LeRand's Way - Little Diamond  
Pier Reconstruction Island

Project Name: **Old Coast Guard Pier Reconstruction**  
Project ID: 2013-109  
Address: 6 Rand's Way, Little Diamond Island  
CBL: 105 Z022 001  
Applicant: Charles (Kip) Moore  
Planner: Jean Fraser

On July 24<sup>th</sup>, 2013, the Planning Authority approved with conditions a Level I: Site Alteration site plan for reconstruction of the existing pier within the same footprint, and associated increase to the existing building elevations, located at 6 Rand's Way, Little Diamond Island.

Drawing file: Approved Plans / RRS Survey Plan Update 5.24.13.pdf

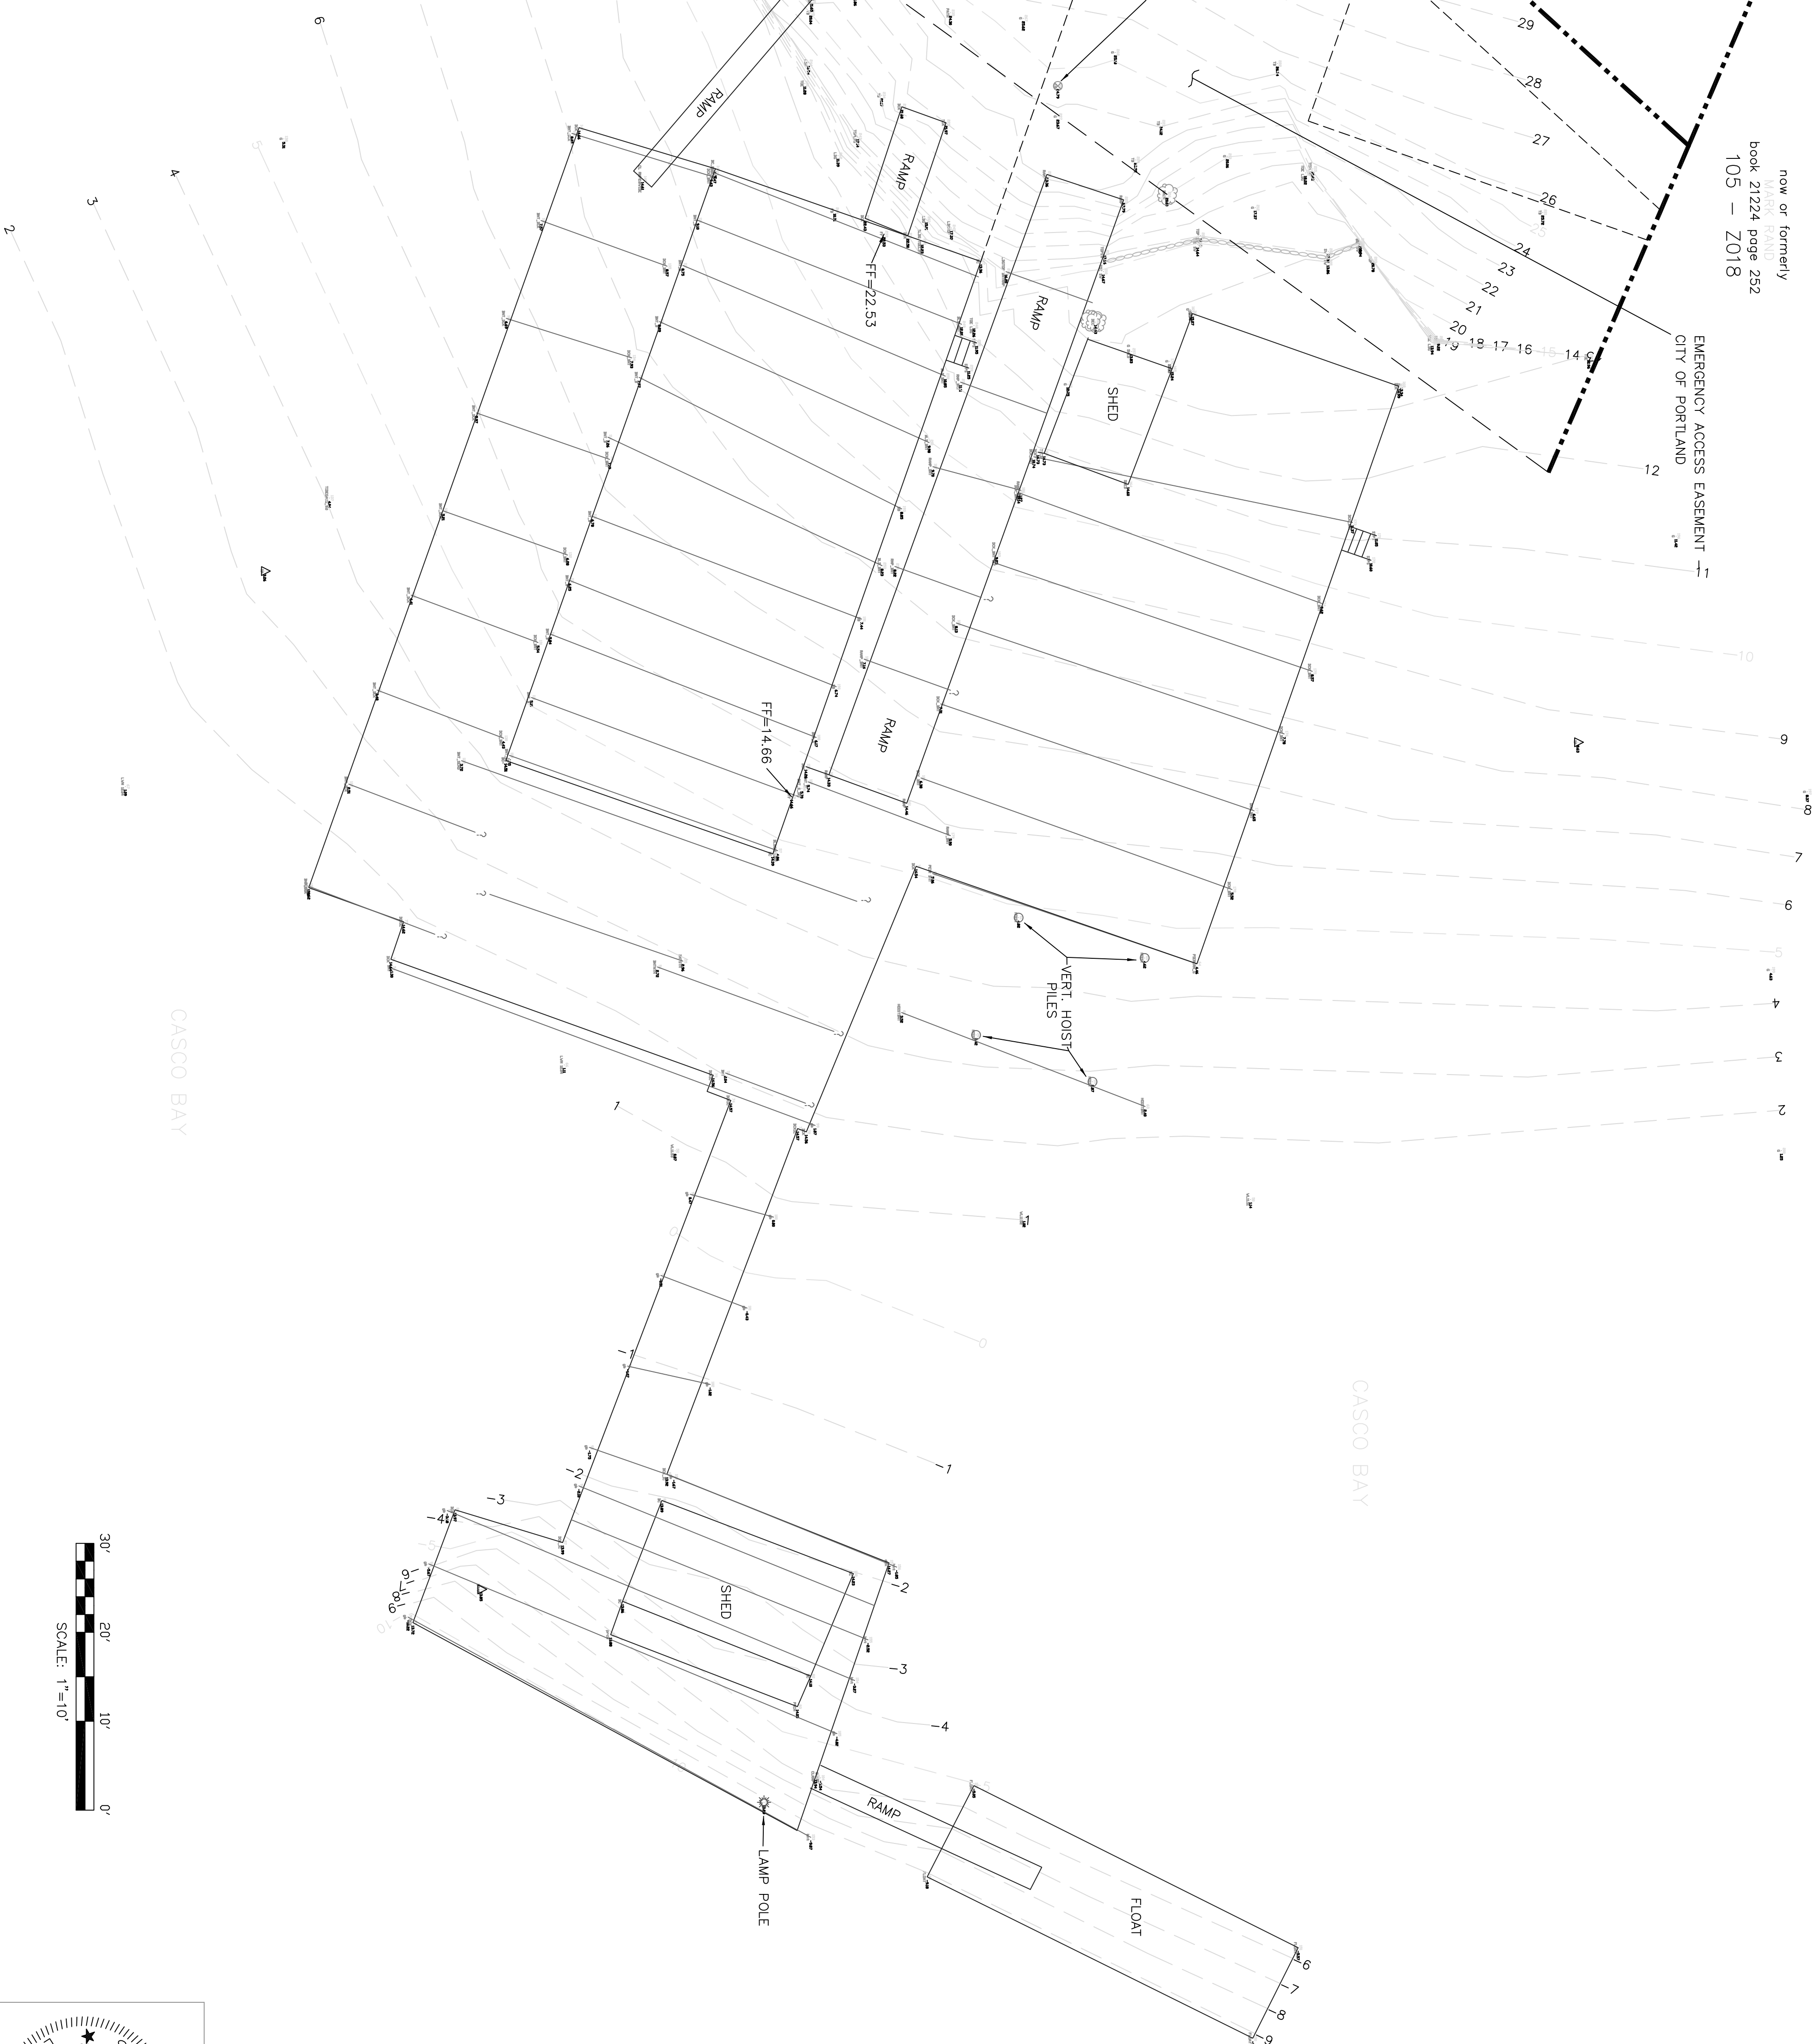
I note that you have requested a waiver of the boundary survey requirement and you stated that the topographic survey for the site has been completed by a licensed PLS. We seldom waive this fundamental requirement (a current application for reconstruction of a smaller dock on another island has been requested to submit, and has submitted, a full boundary survey), but in this case it may be possible if you can have the licensed surveyor stamp the "existing conditions" plan in respect of the topography, and if you can provide some survey information on the "existing conditions plan" (also stamped by the surveyor) that ties it into the subdivision plat ("amended recording plat" 1988) and to the State Plane coordinates (see below). I note that the 1988 plat shows the pier and associated buildings somewhat differently from the existing conditions plan.

(14-527) Boundary survey stamped by a professional surveyor licensed to practice in the State of Maine, drawn to scale and tied into the State Plane Coordinates, NAD 1983, Maine West Zone, as specified in Section 13 of the Technical Manual.

Thank you for the revised survey which addresses my concerns; I do not need any further information. From the site plan perspective I am ready to sign off but have not yet seen the Zoning Administrator comments and also need Chris Pirone to sign off- I see he has sent you a further question. Feel free to contact Marge Schmuckal re the Flood Hazard Development permit if you wish, but I will follow up with her in any case.

**BOUNDARY SURVEY REQUIREMENTS**-We had our surveyor prepare the attached plan to address your comments with regard to the Boundary Survey requirements. Please let me know if you need any additional information to process the permit application.
